**From:** "McGee, Martin" <Martin.McGee@FMR.COM>  
**To:** "'JF@portlandmaine.gov'" <JF@portlandmaine.gov>  
**CC:** "'mcgeekm@verizon.net'" <mcgeekm@verizon.net>  
**Date:** 10/11/2013 10:53 AM  
**Subject:** Concerns and Questions regarding 133 York Street

We're sending you this email because we have a number of serious concerns and questions related to the proposed development at 133 York St. which abuts our property.

EROSION CONTROL AND LANDSCAPE PLAN

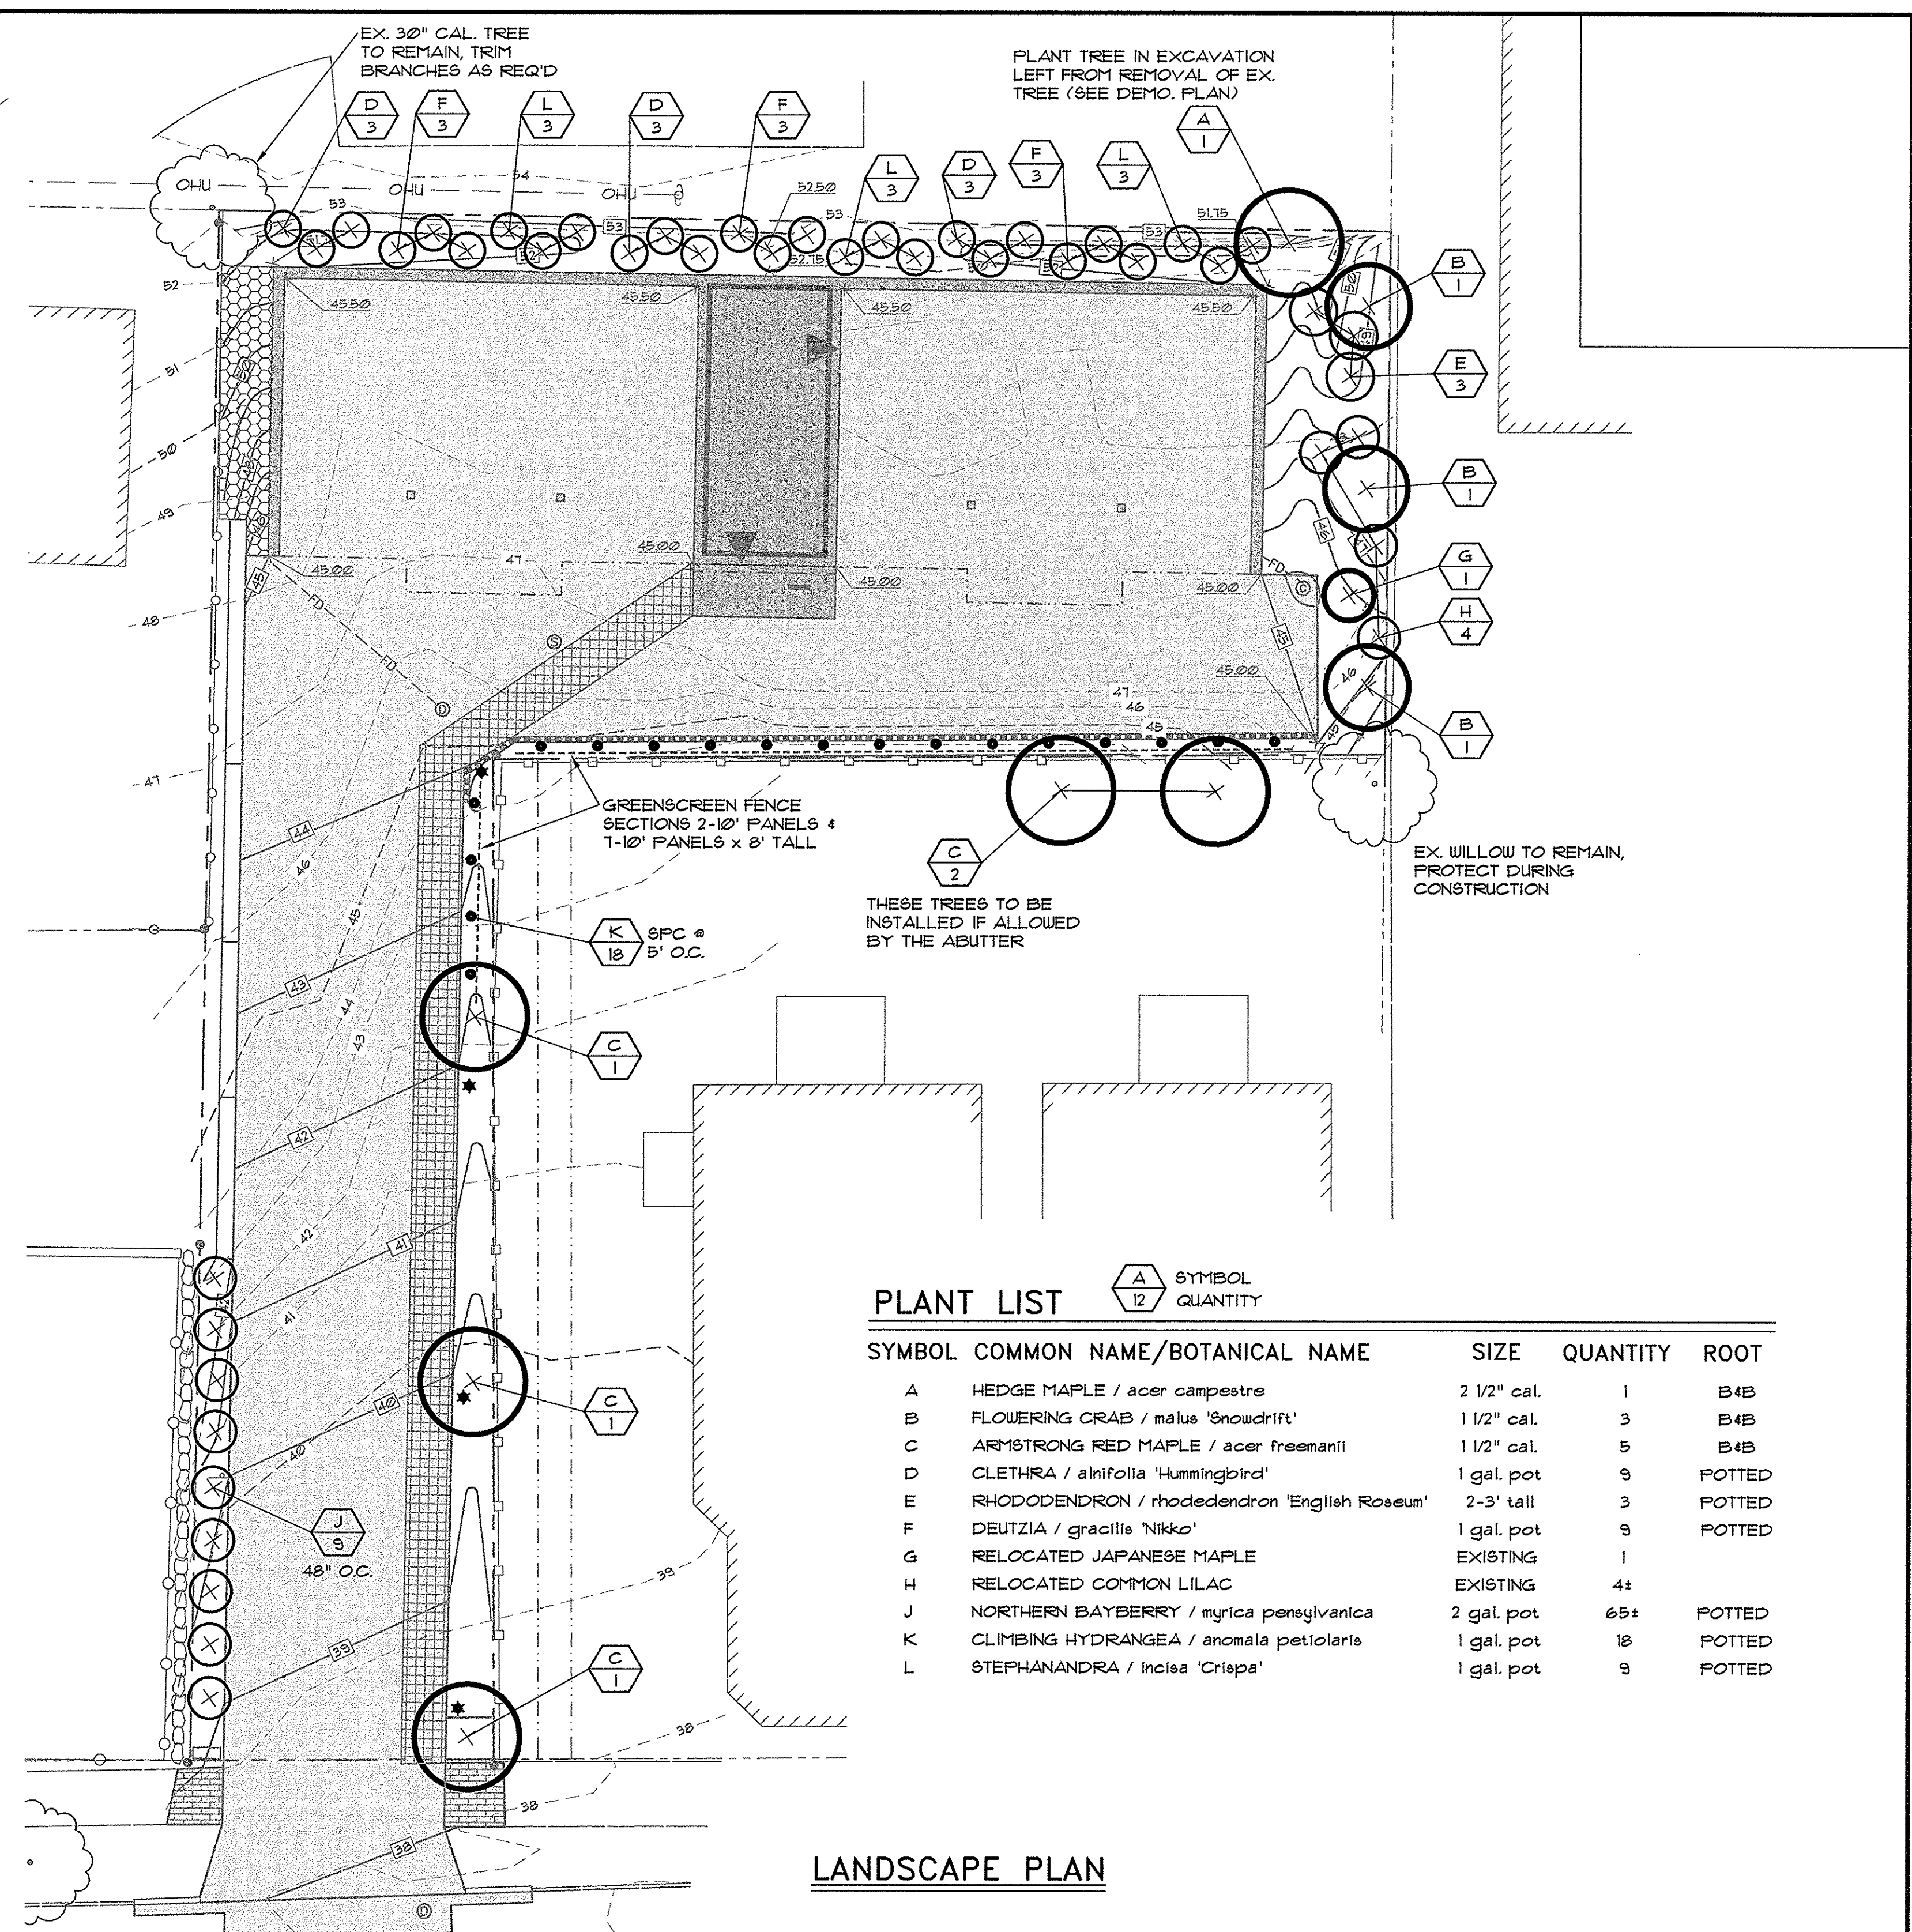
3. **Tree Removal.** Another important amenity to the enjoyment of our property is the greenery on and around our property. It is our understanding that the developer plans to remove all trees on or near the property (including those with a base on our property) without any plans for replacement when construction is completed. This will take away from the natural aspects of the surrounding area and create an unattractive, stoic environment. We are very concerned about this also.

SOUTHWEST VIEW

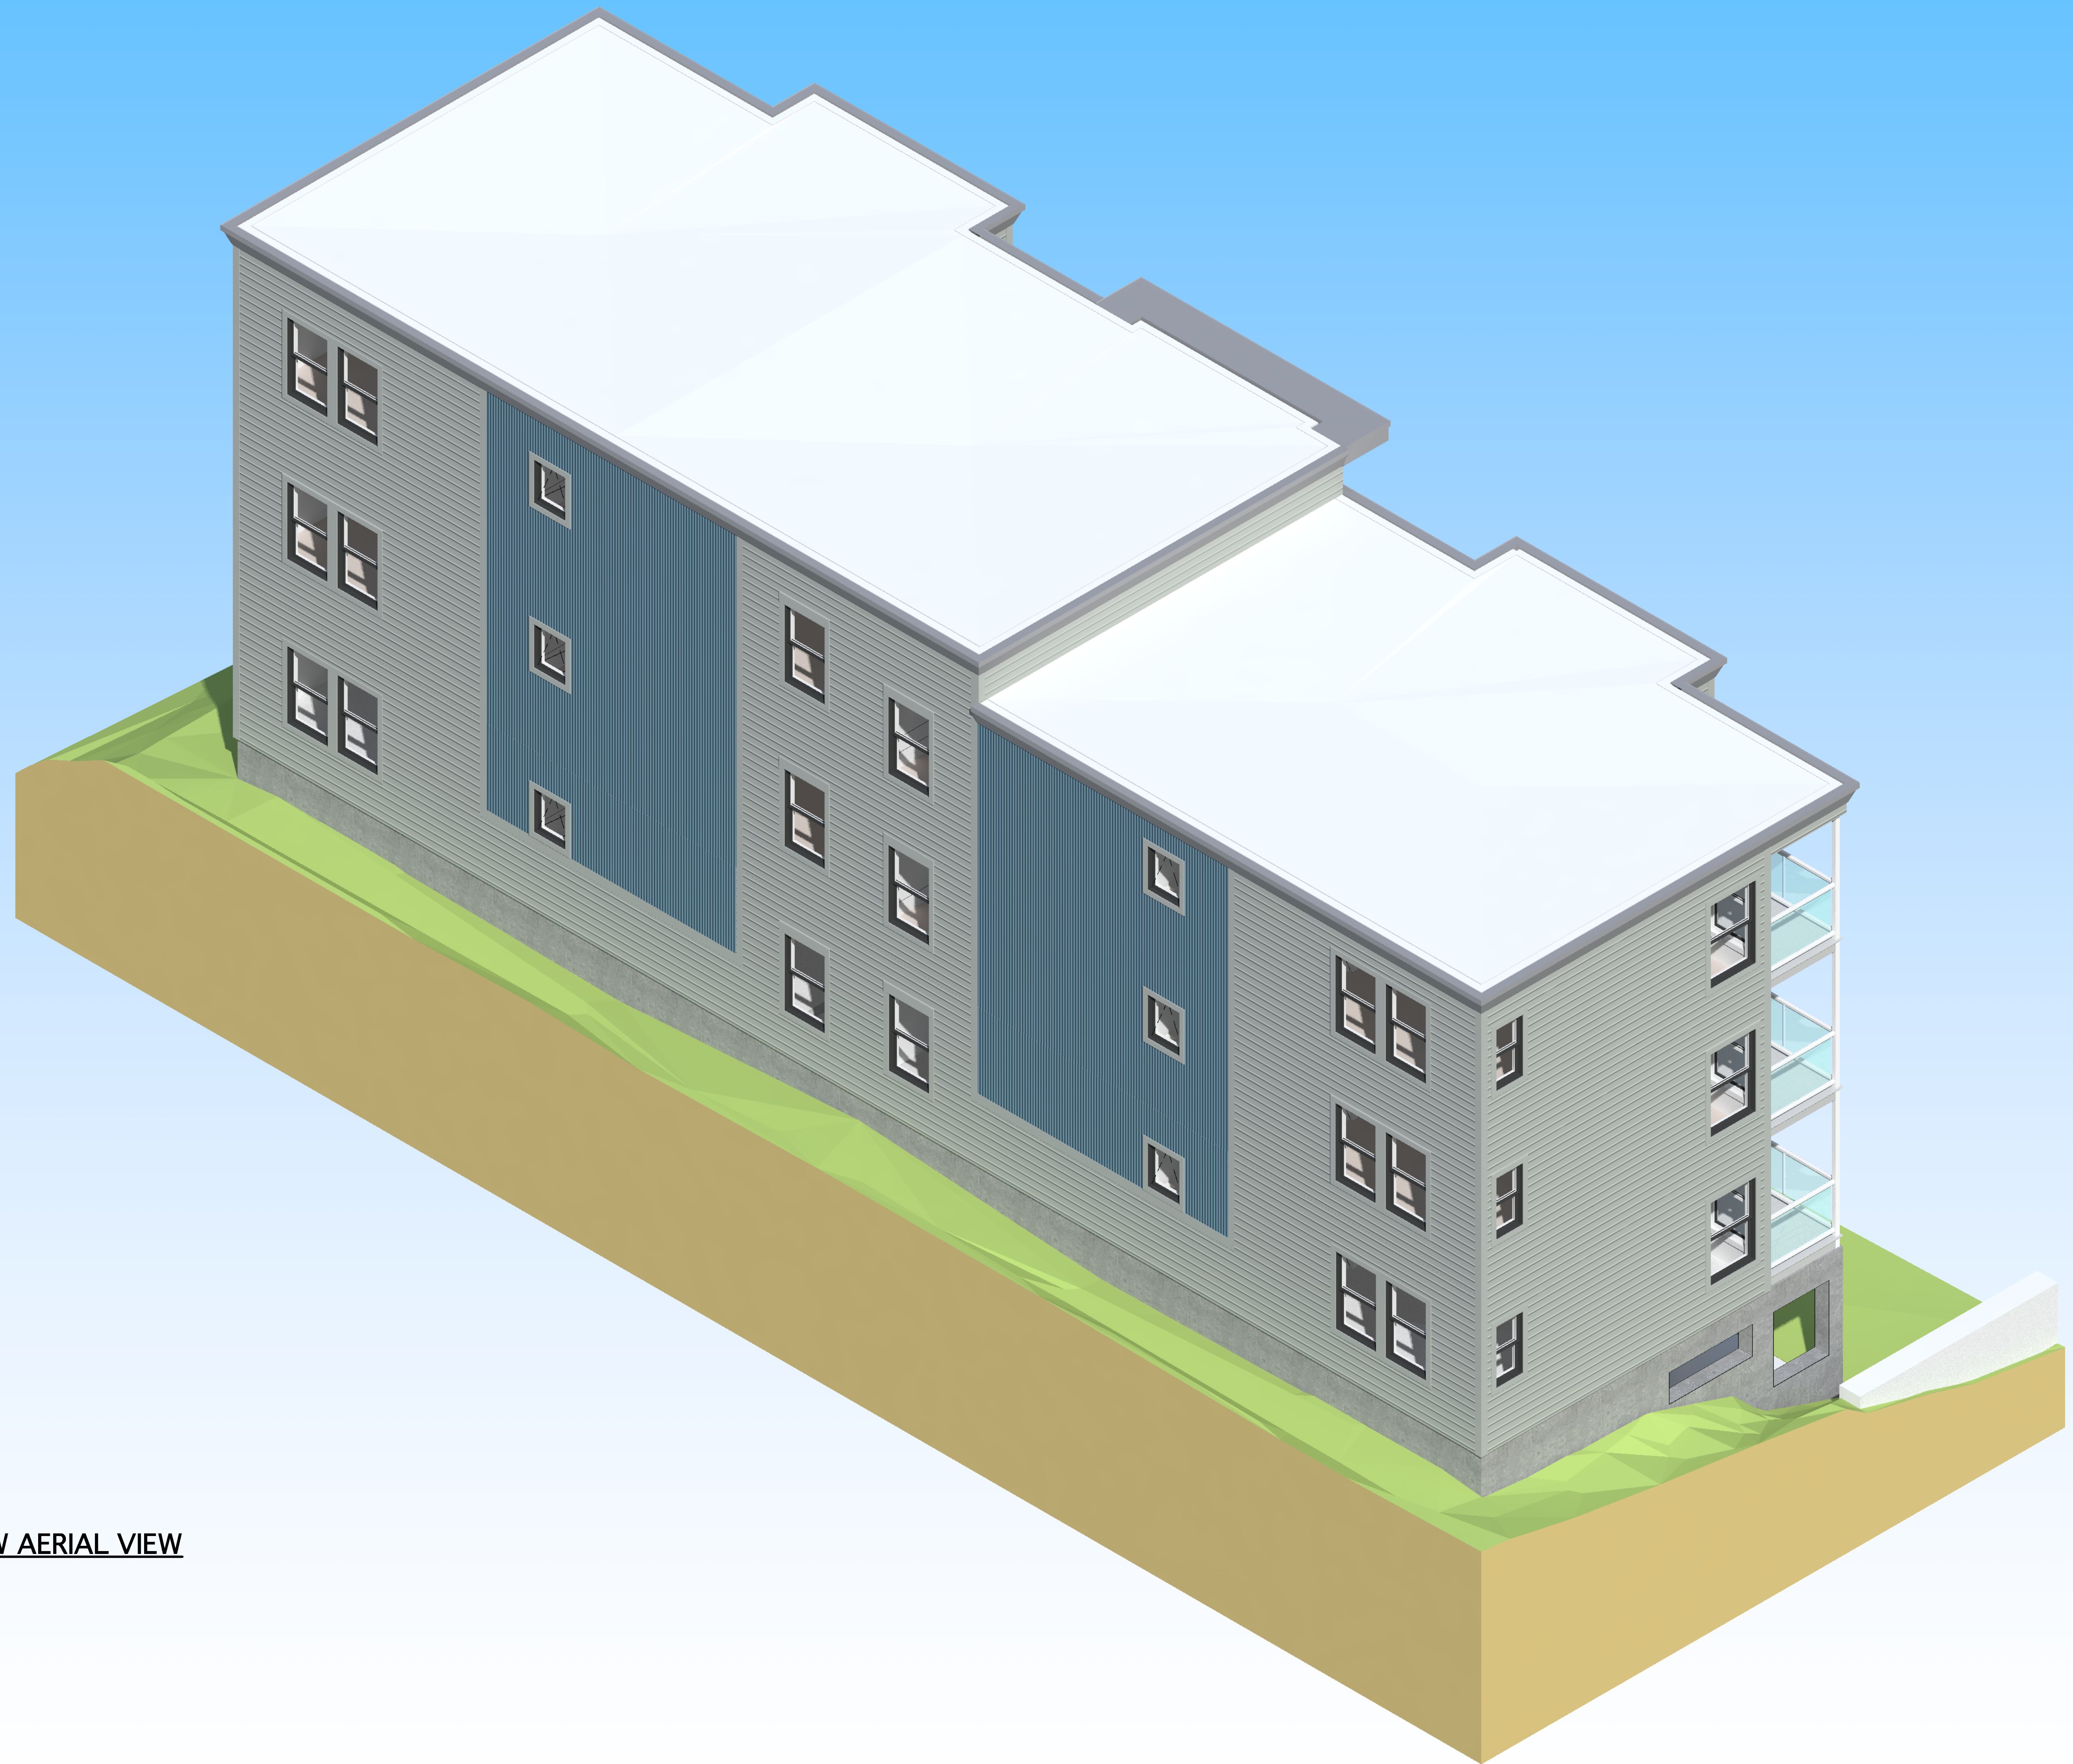
2. **Design of the Building.** The view from the rear of the building, our view, from the designs provided to this date, is uninspiring and doesn't fit in with the neighborhood. As we will be forced to look at this buildings rear view (if approved), it should at least be something that is pleasant to look at. And, as mentioned below, the lack of substantive greenery is definitely disappointing.
